## 33 Hampshire St - Permit #2017-00905

**Matthew Ahlberg** <matthew.ahlberg@barrettmade.com>

Tue, Jun 20, 2017 at 4:14 PM

**33 HAMPSHIRE STREET
FLOOR PLANS**

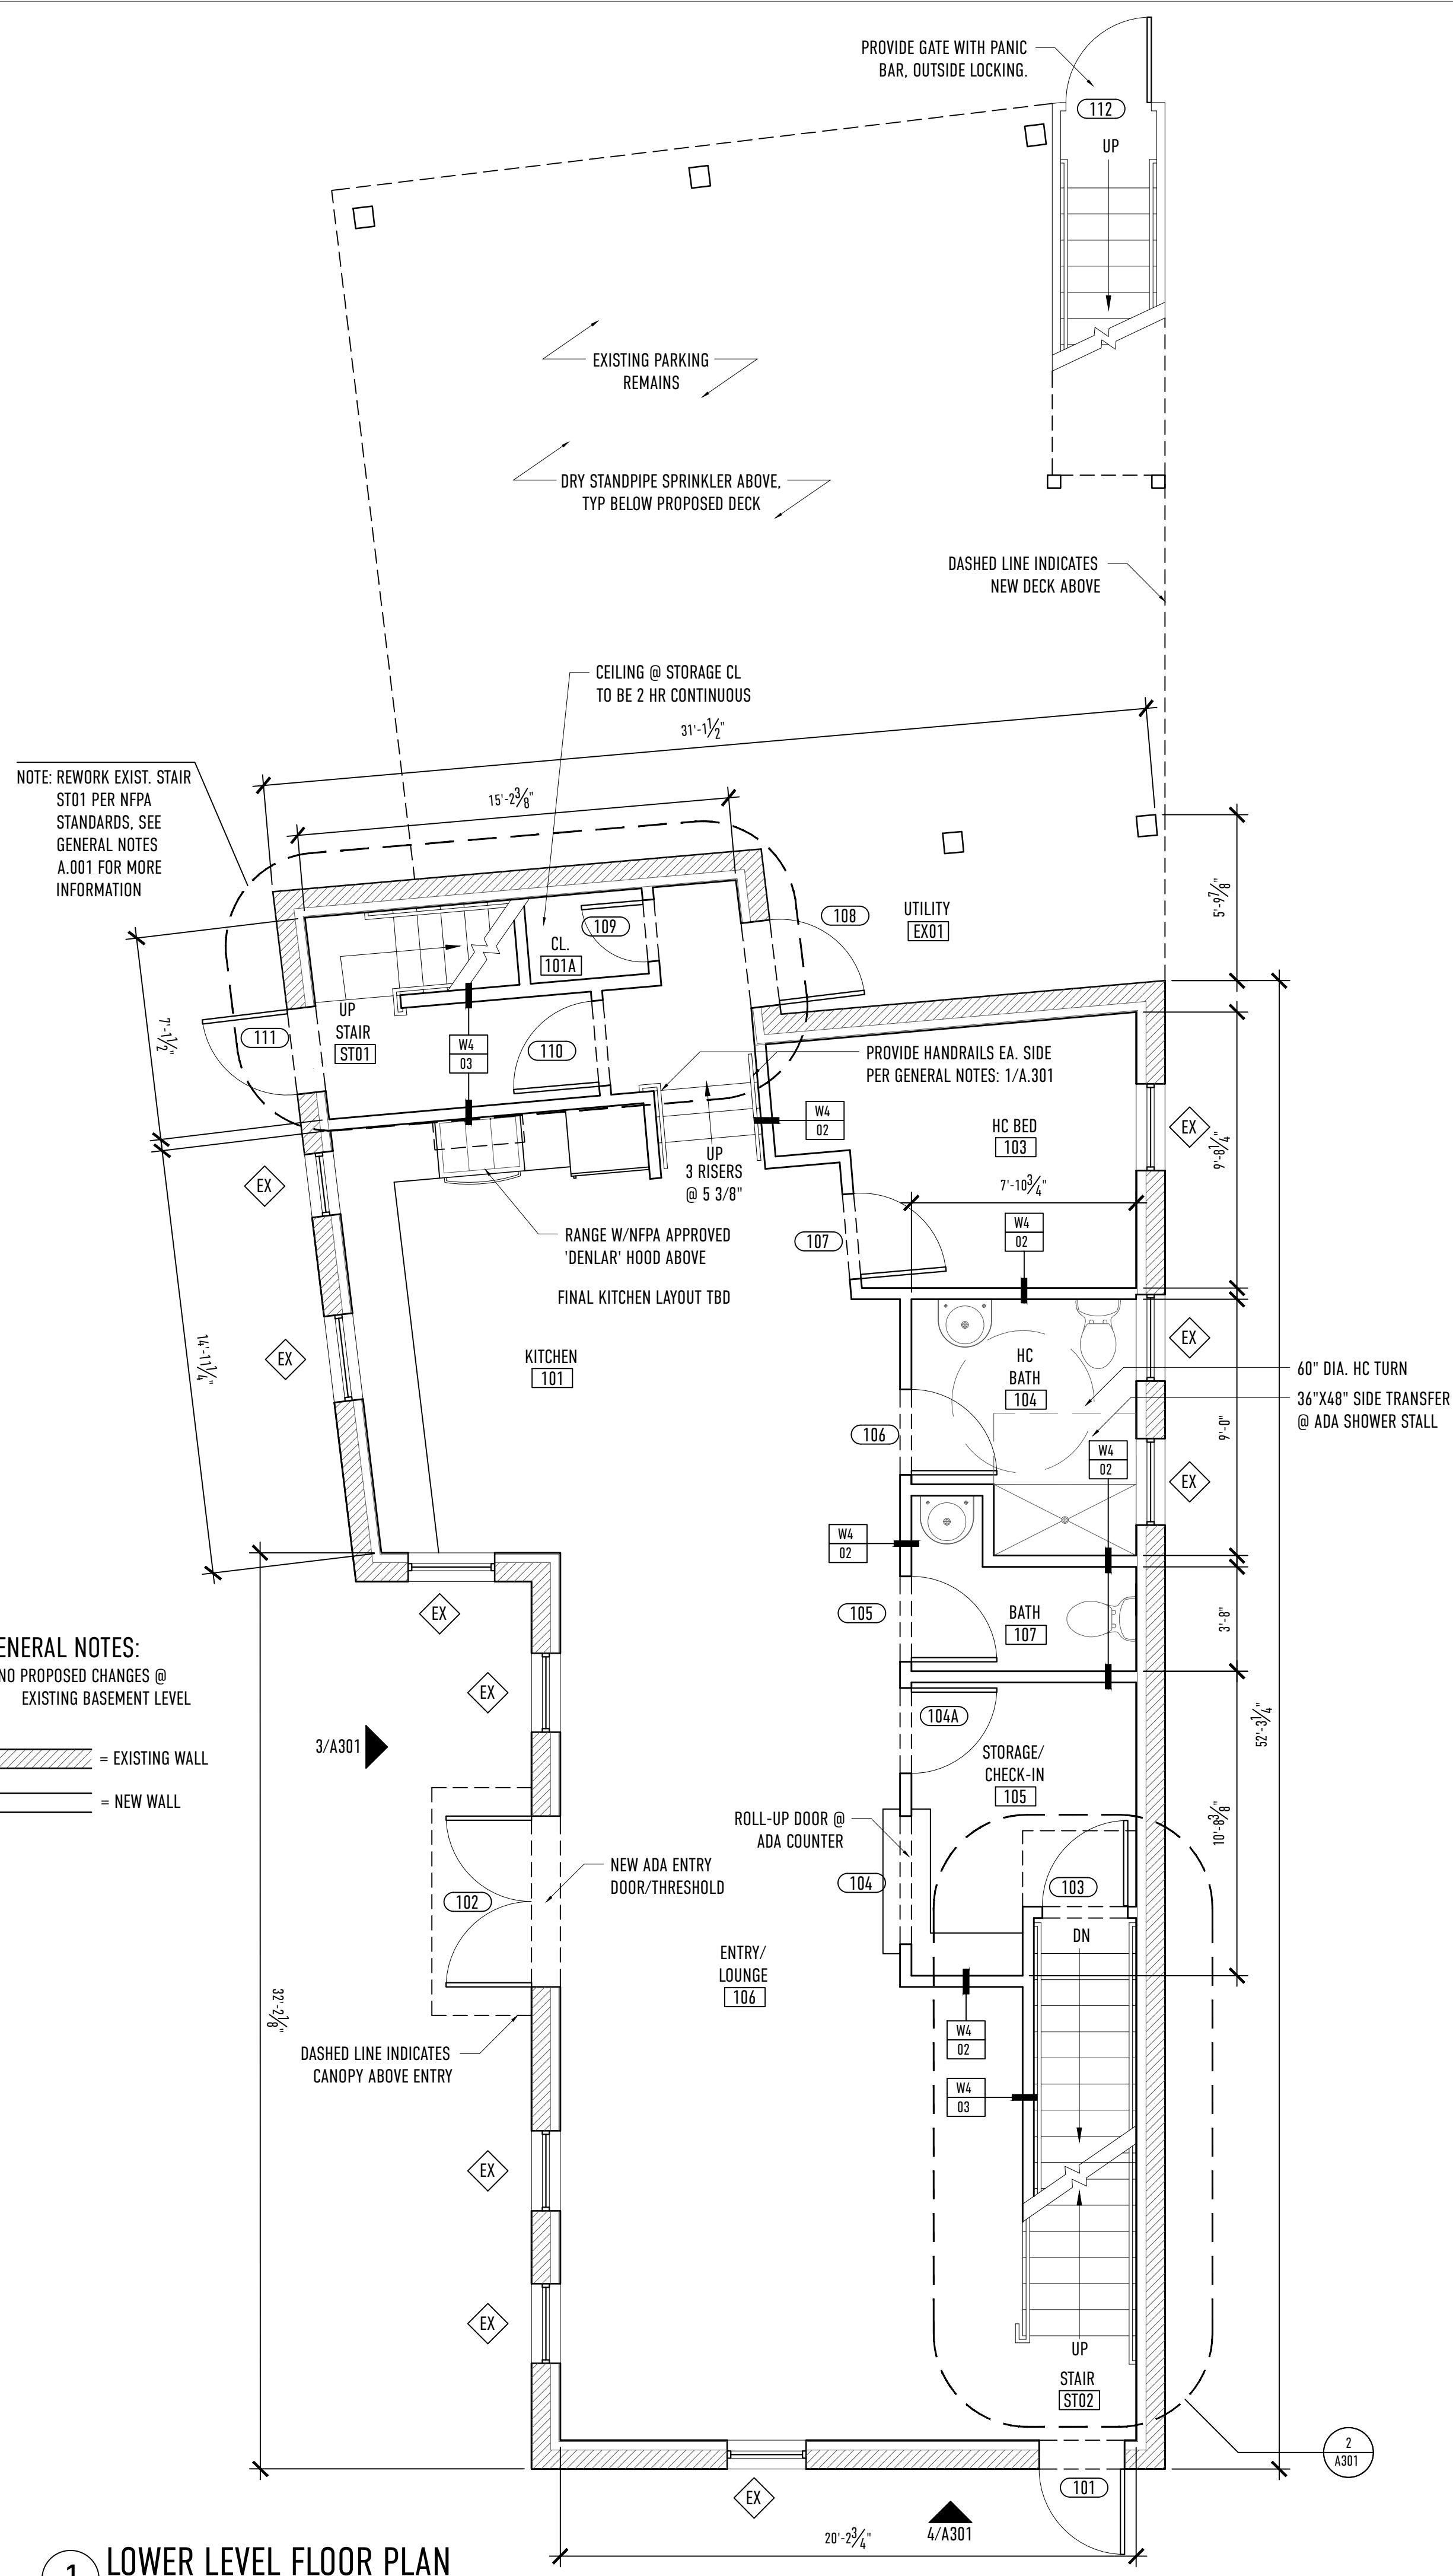
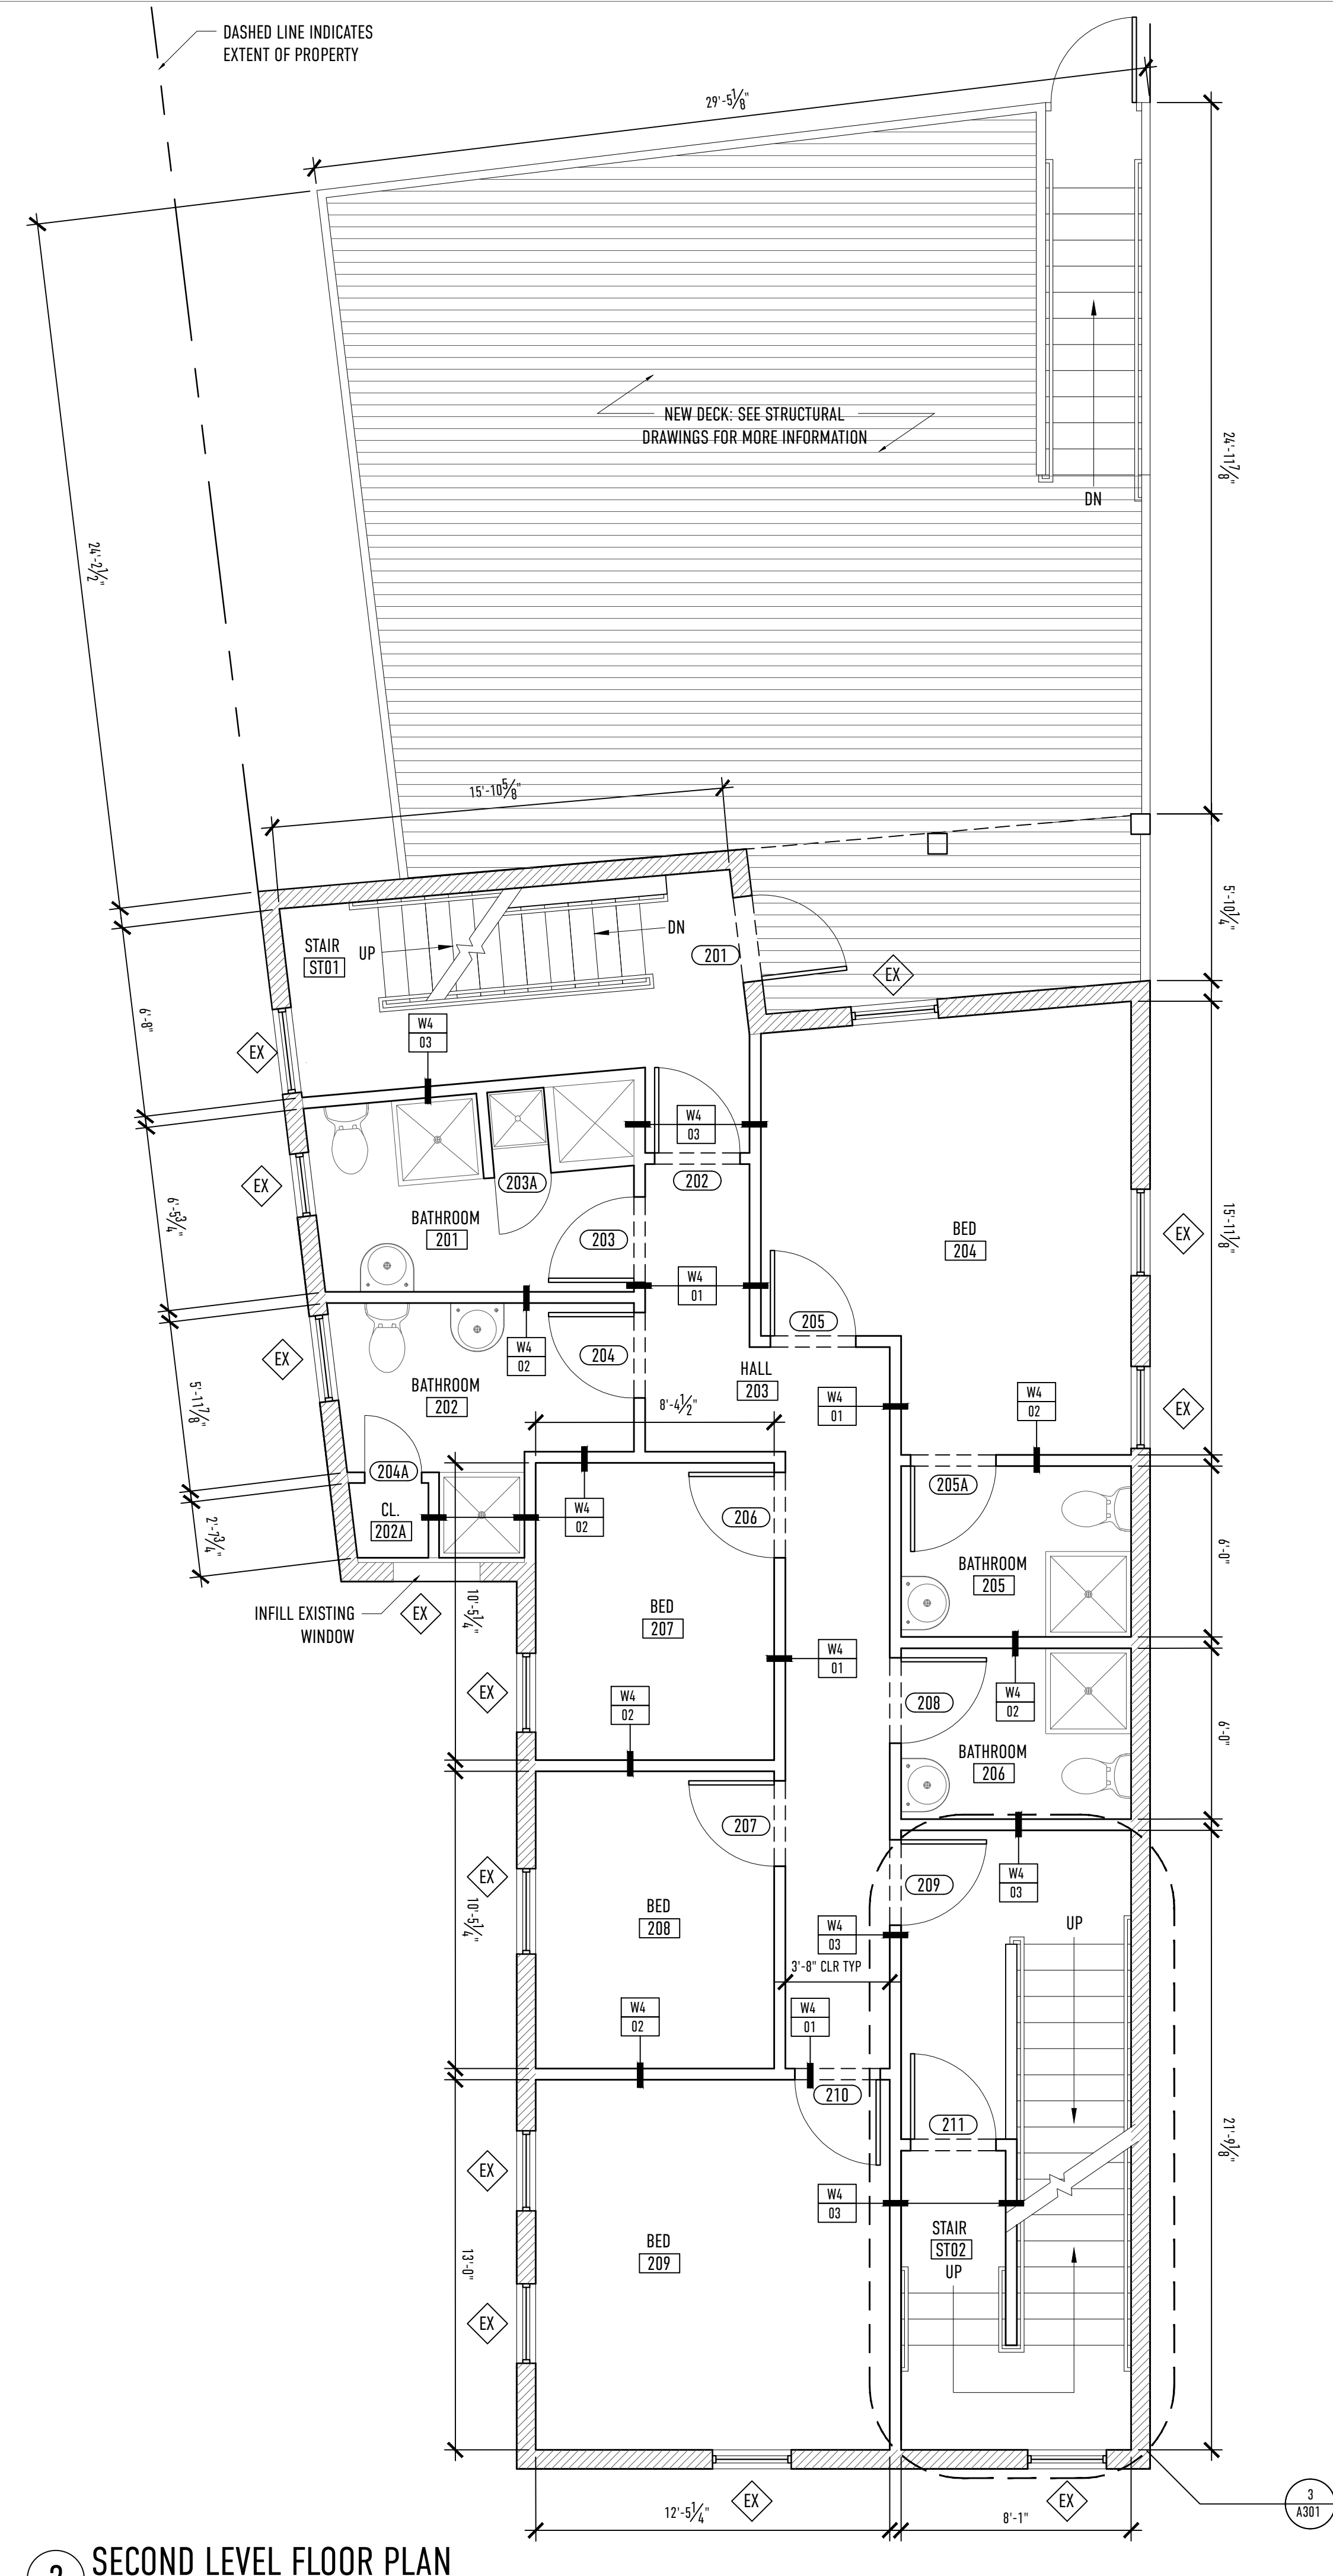
1) Regarding the small canopy over the new entry door facing Hampshire St, will this be extending over the city road right of way? It appears that it will be, but there was no survey included so I could not confirm. If so, there is a licensing process for structures over city property that you will need to complete.

**We are assuming that this is extending over city property and will pursue the avenue of the licensing that you are referencing.**

2) Is the plan still to park two cars under the deck, plus another in the driveway next to the deck? As we discussed via e-mail previously, the number of parking spaces on the lot cannot be reduced, so I just wanted to confirm that this still is the plan.

**That is correct, the deck is designed to accommodate existing parking while working within the buildable envelope on the site.**
